Please ask for: Ms Iqraa Malik
Email: iqraa.malik@terraquest.co.uk
Telephone: 0121 234 1390
Our Ref: A/63/25/HH
Your Ref:
Date: 14th April 2025

Application for Planning Permission for Works or Extension to a Dwelling

Development: Erection of single storey rear extension.
Location: 41 Oakwood Drive Angmering BN16 4GB

PROPOSED GROUND FLOOR PLAN (SCALE 1:50)

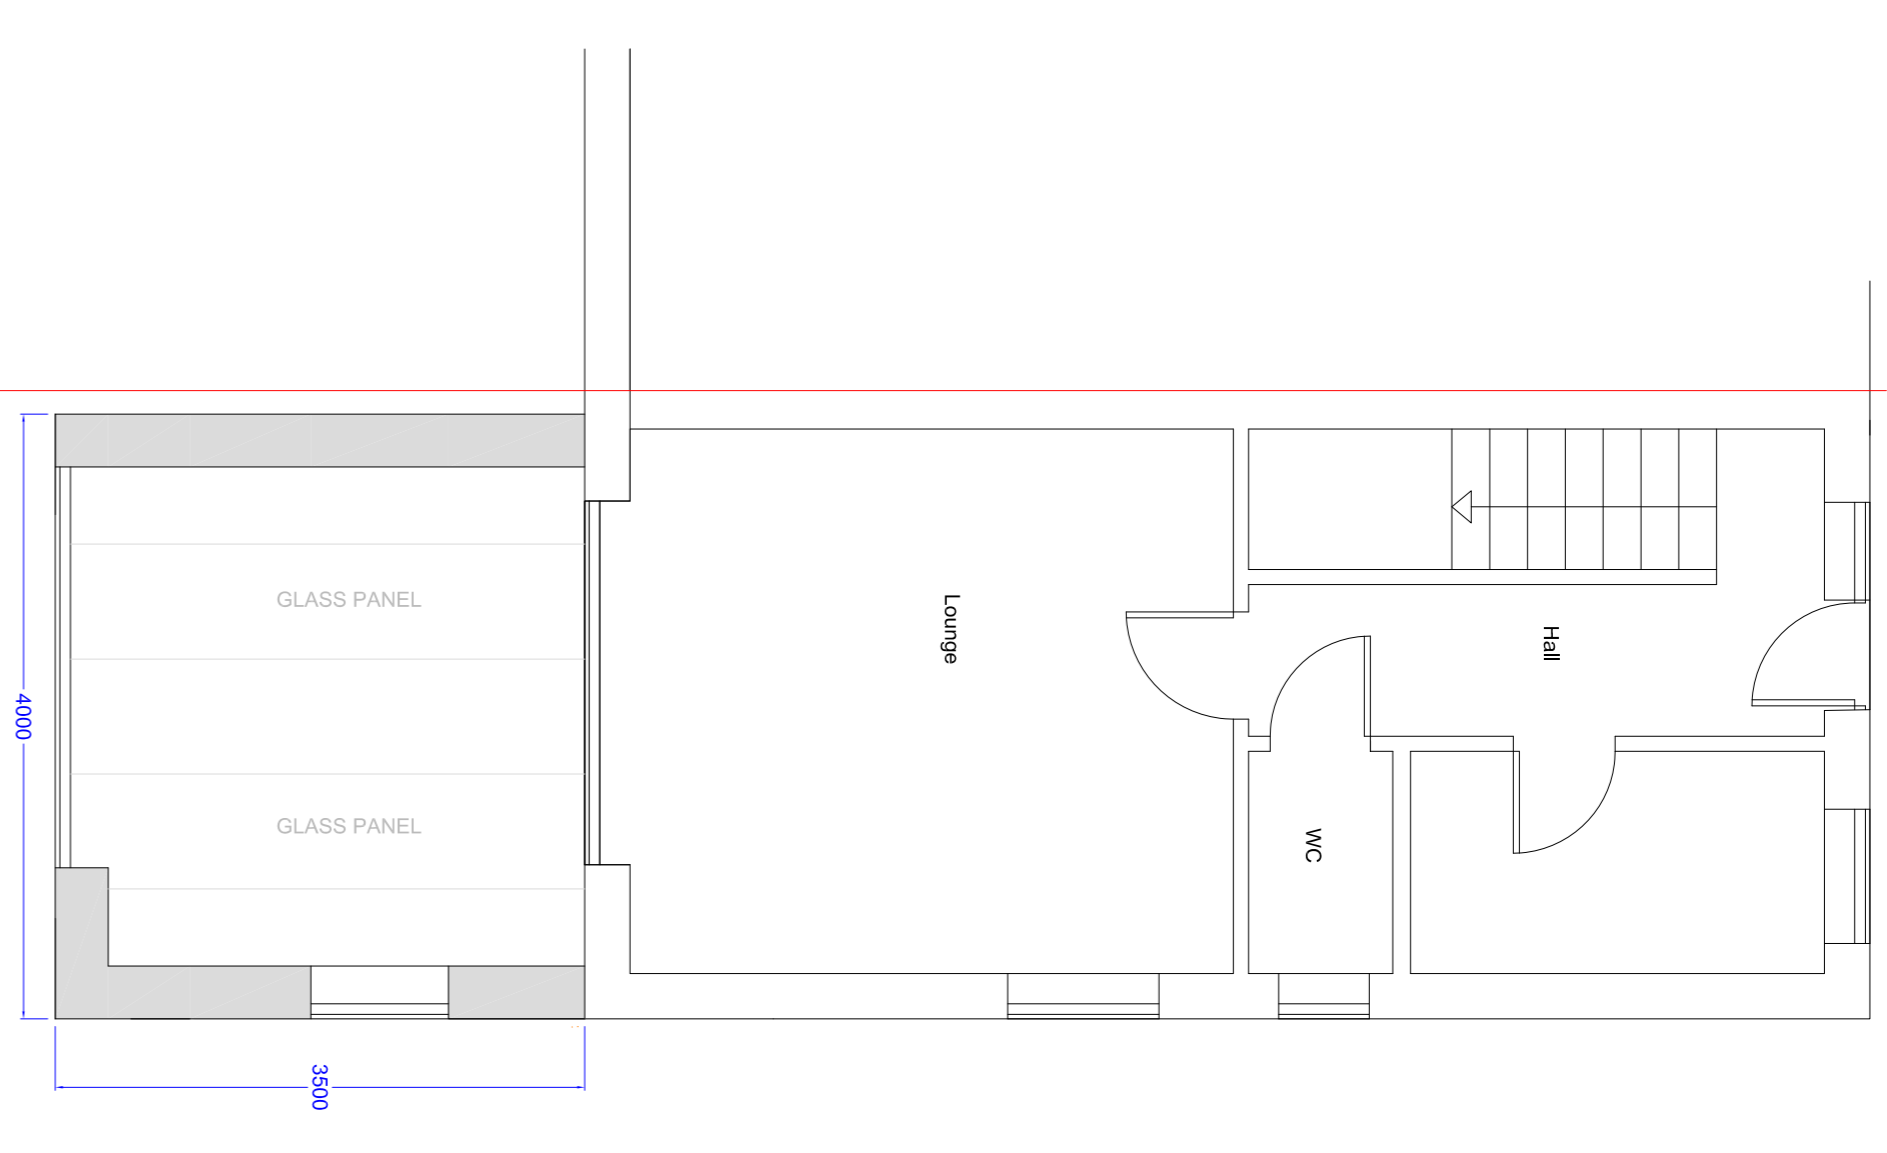
Floor Plans

Please show the proposed rooflights on the proposed floor plan.
